EPL 20434/DOC18/920867-2

**RE: SSD 09\_0103 – Boco Rock Wind Project (EPL 20434) – MOD 1 – Stage 2 Development**

## **Attachment 1 - SSD 09 0103 – Boco Rock Wind Project**

Assessment Curves: Stage Two Mod = Vestas V150 – 4.2 MW

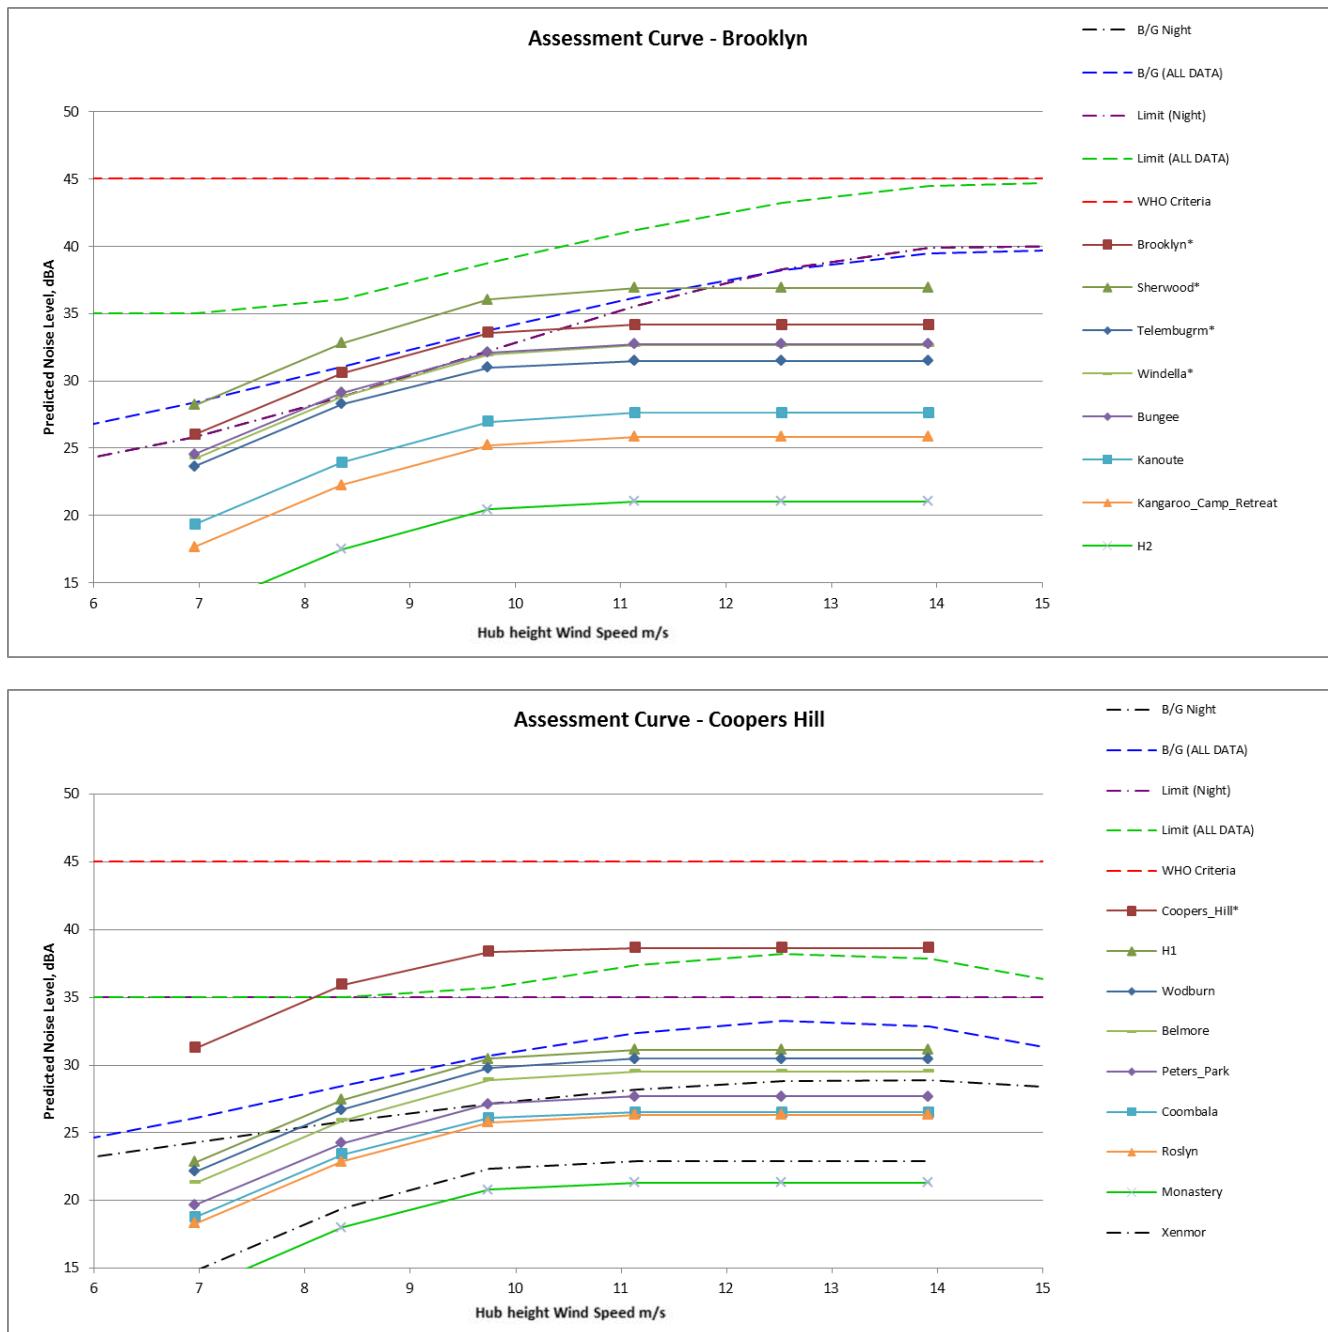
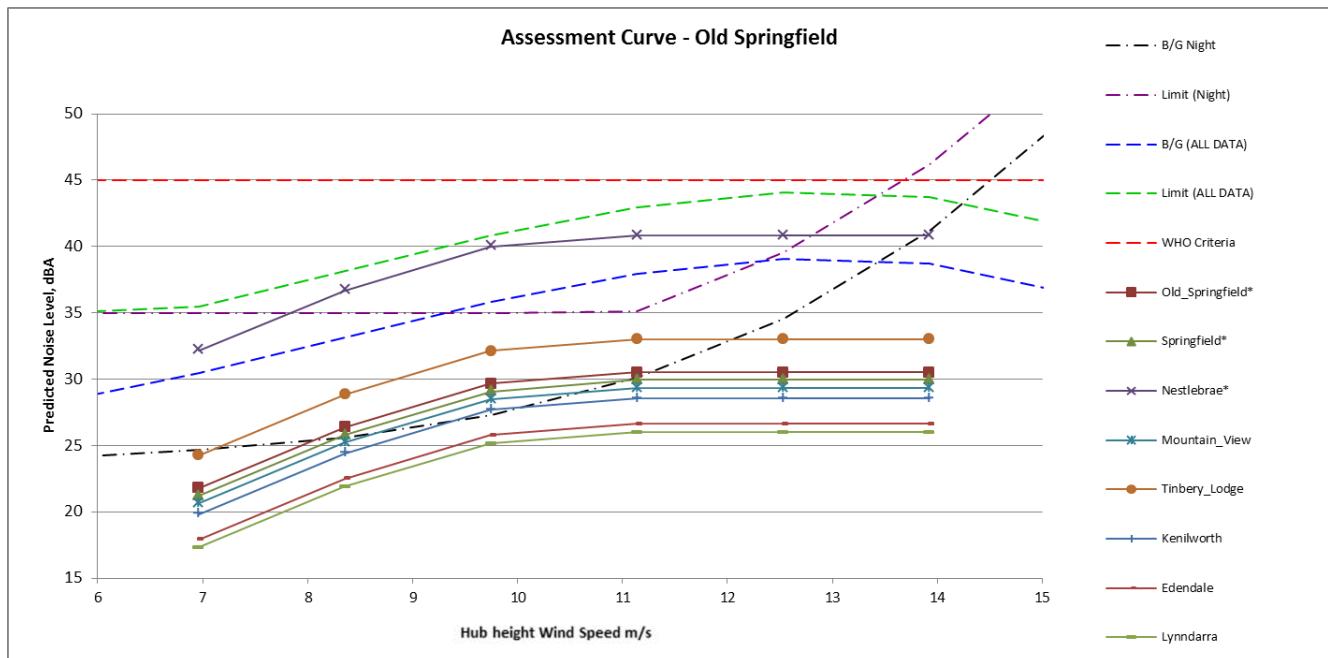
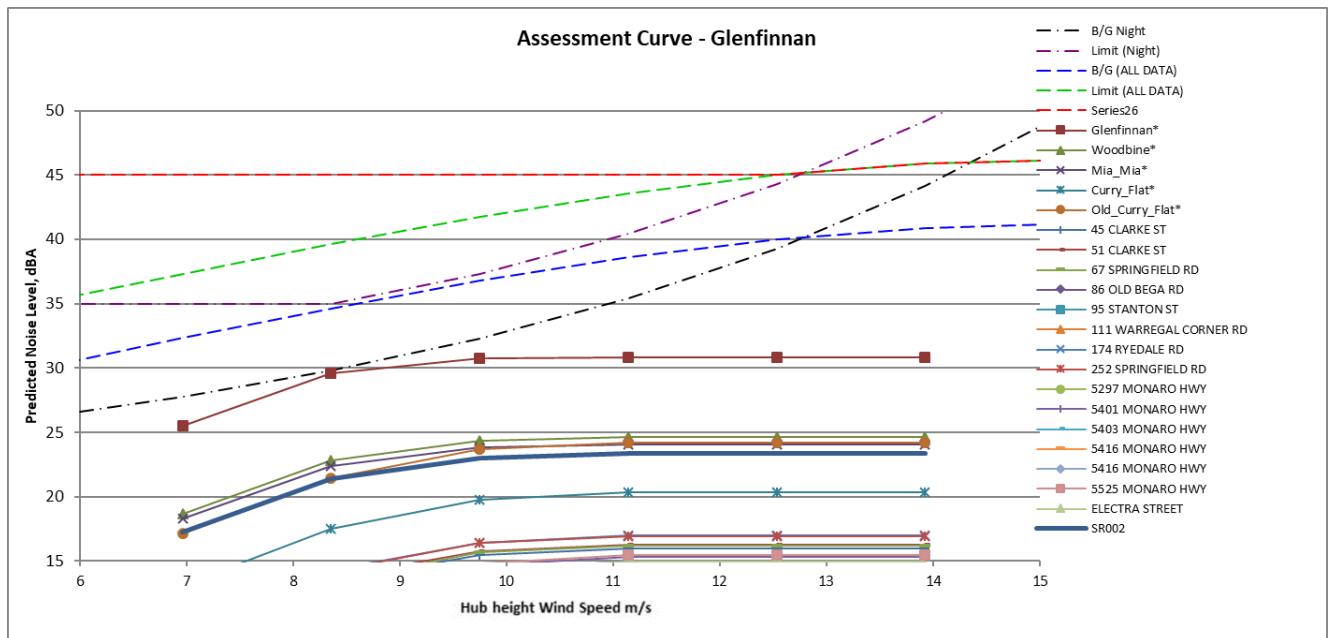
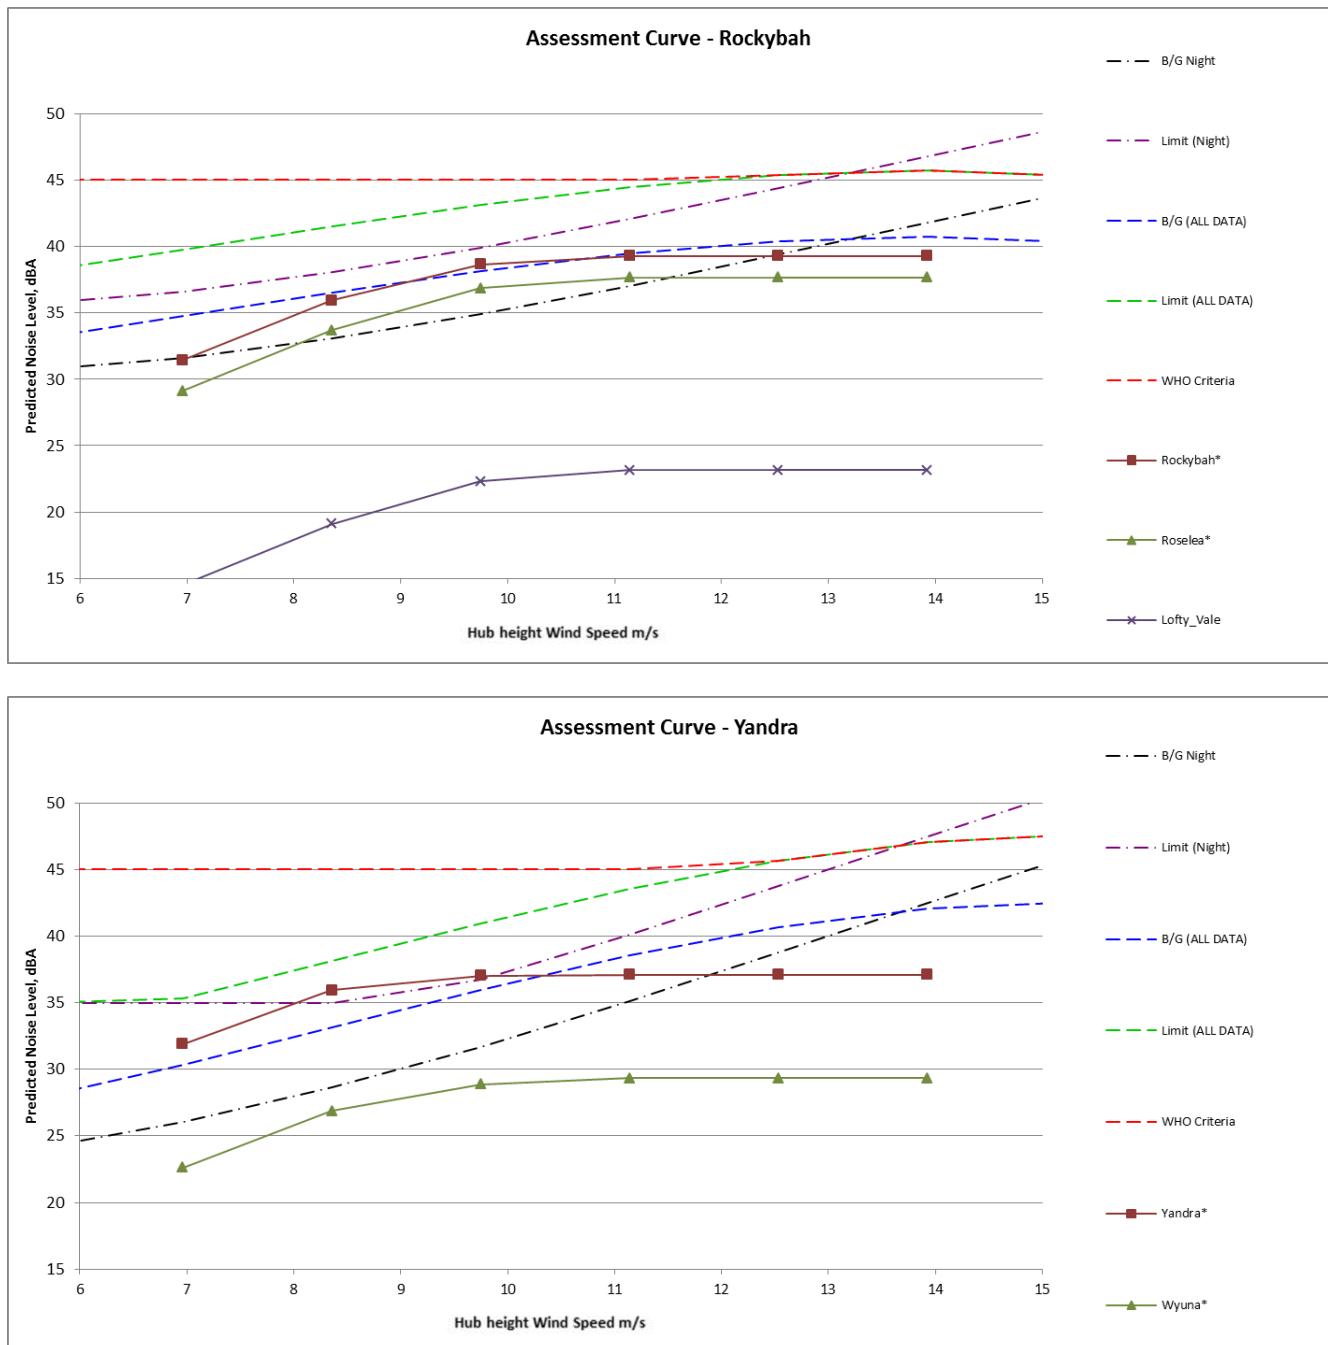
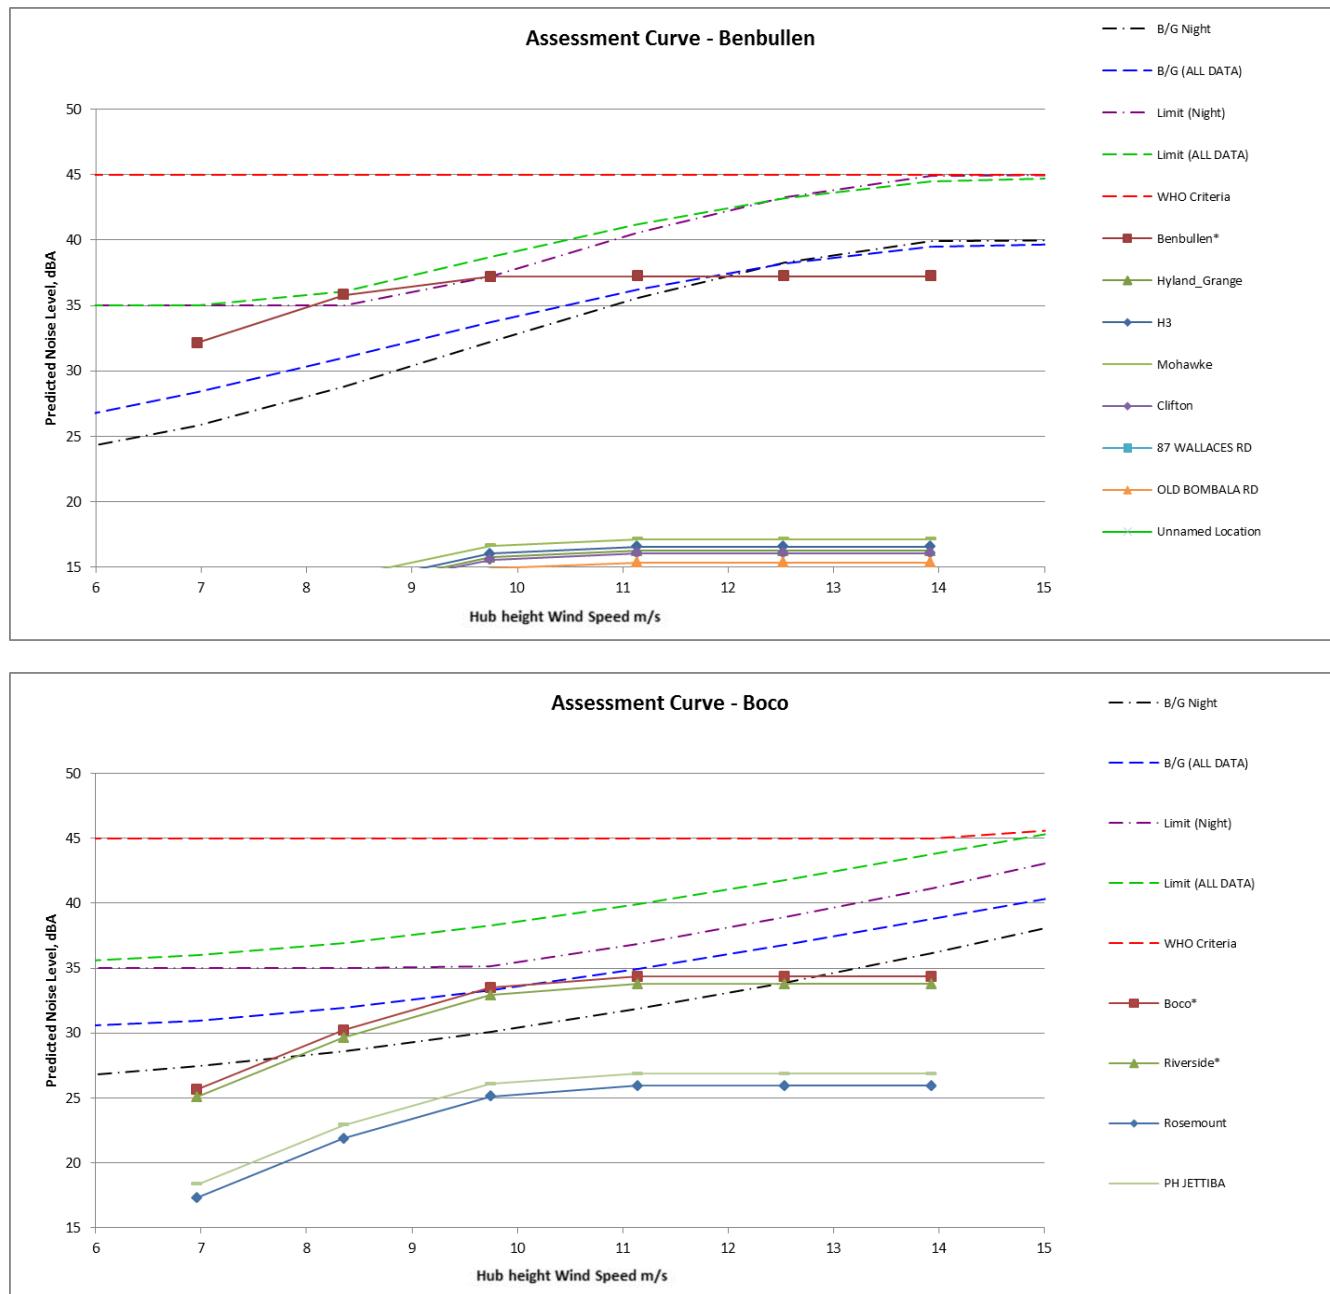
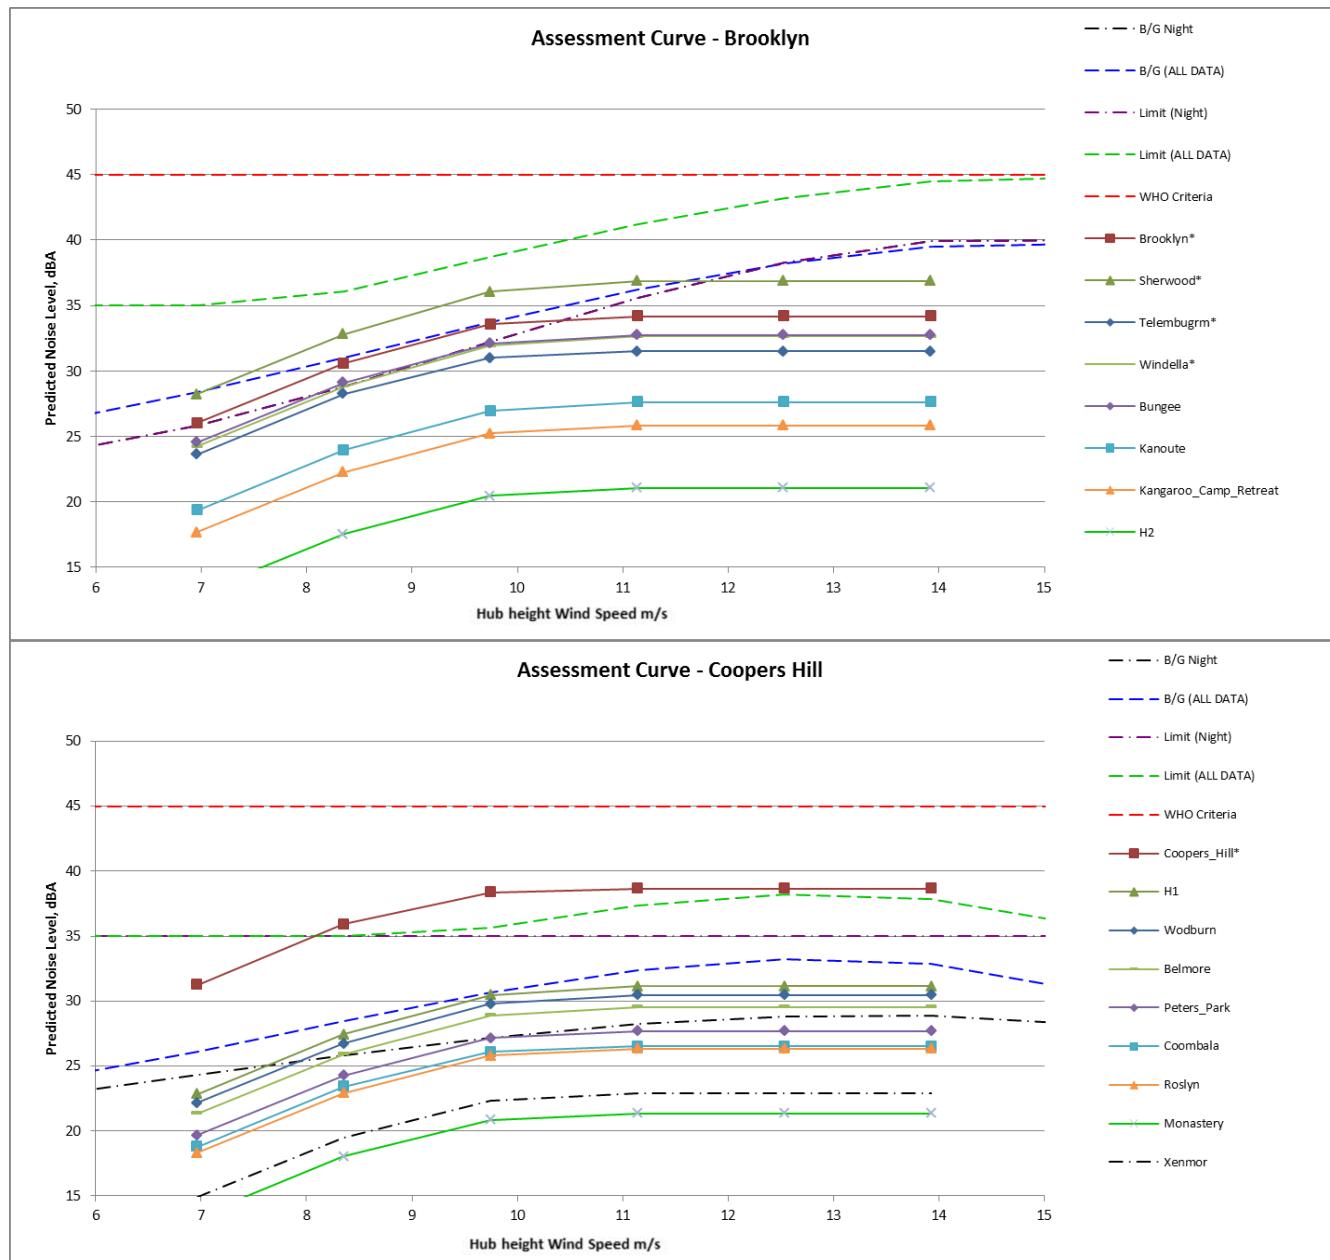
It is also not clear whether the background noise curves in Section 1.1.3, on which the Project criteria are based, have not been derived for winds at WTG hub height. This should be clarified in the RNA.

The EPA also note that Table 9 quotes WTG sound power levels for wind speeds at 10m above ground level. The proponent should explain how these sound power levels are appropriate when predicting noise for wind speeds at hub height.
